BE/106/13/WMA

Application for a non-material amendment following a grant of planning permission.
Town and Country Planning Act 1990

SINGLE STOREY EXTENSION TO BEM ANNEXE

BE/40/13

DRAWING NUMBER 12092/01R1

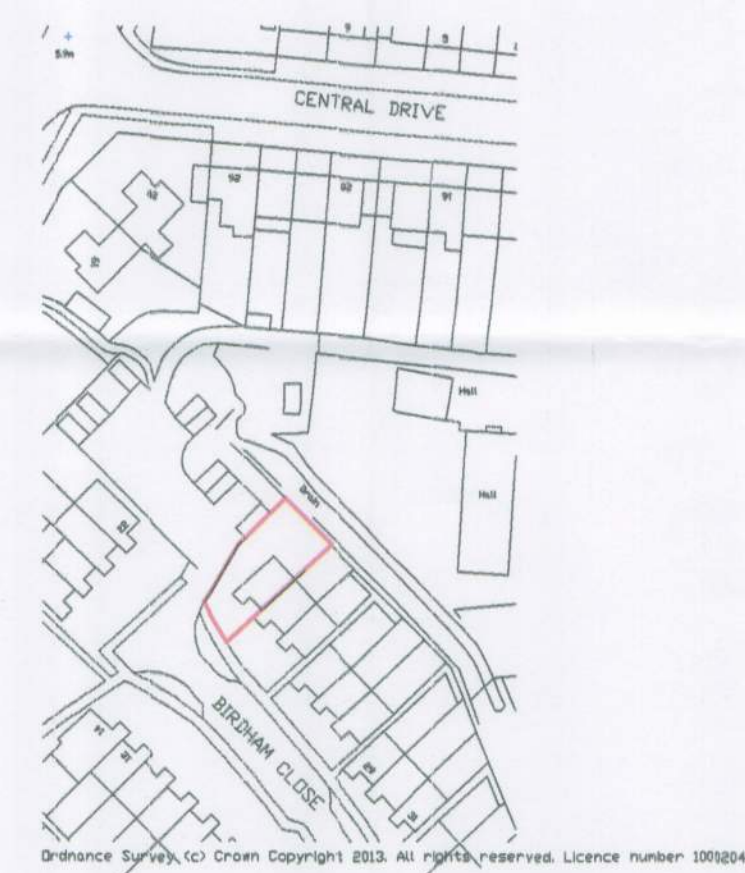
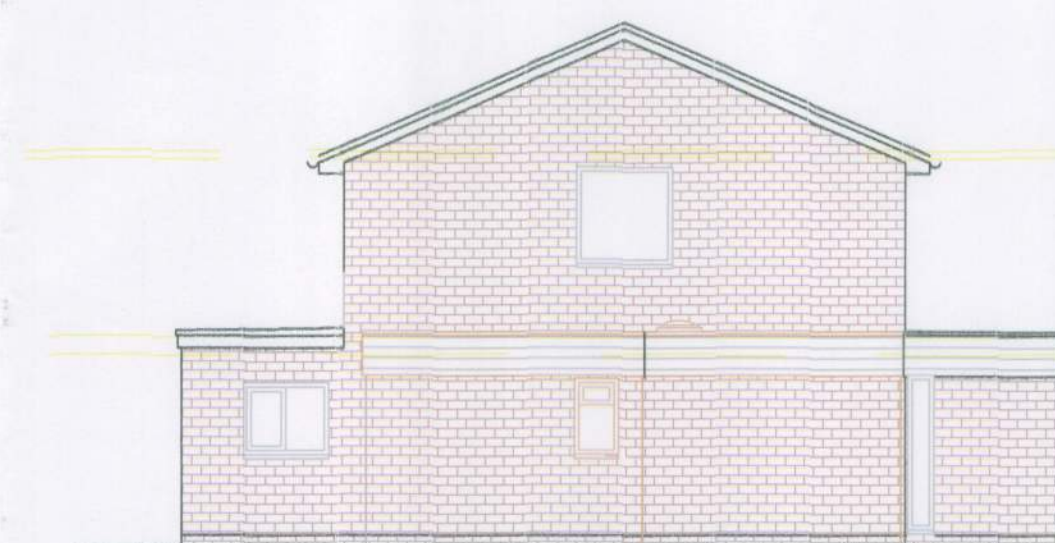
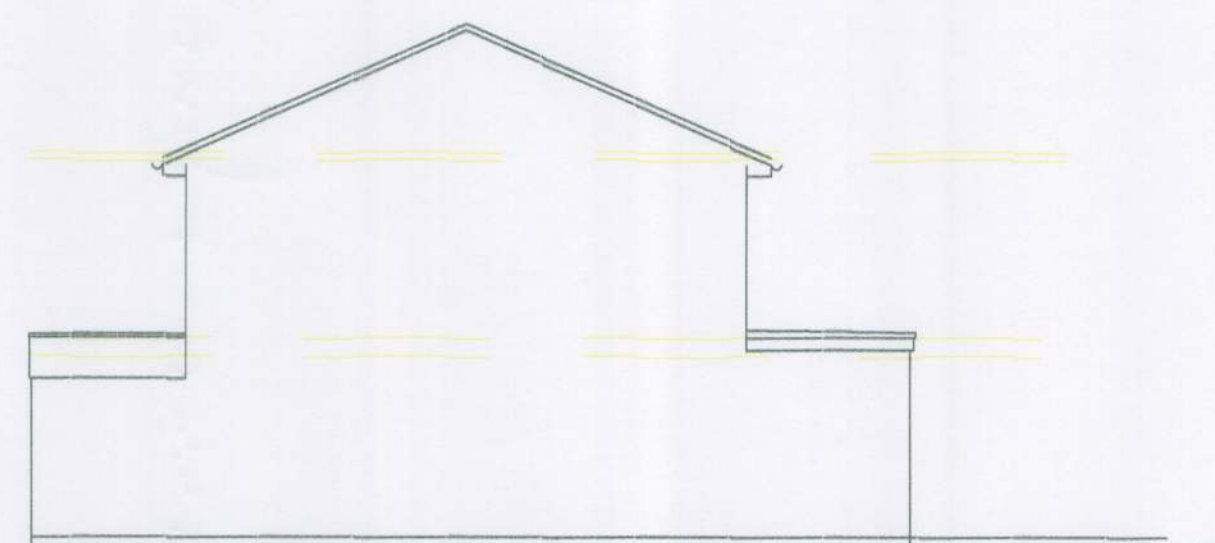
REDUCED SIZE OF EXTENSION DUE TO POSITION OF
PUBLIC DRAINAGE.

DUE TO PUBLIC DRAIN RUNNING UNDER ORIGINALLY
PROPOSED EXTENSION.

12092/01 R1
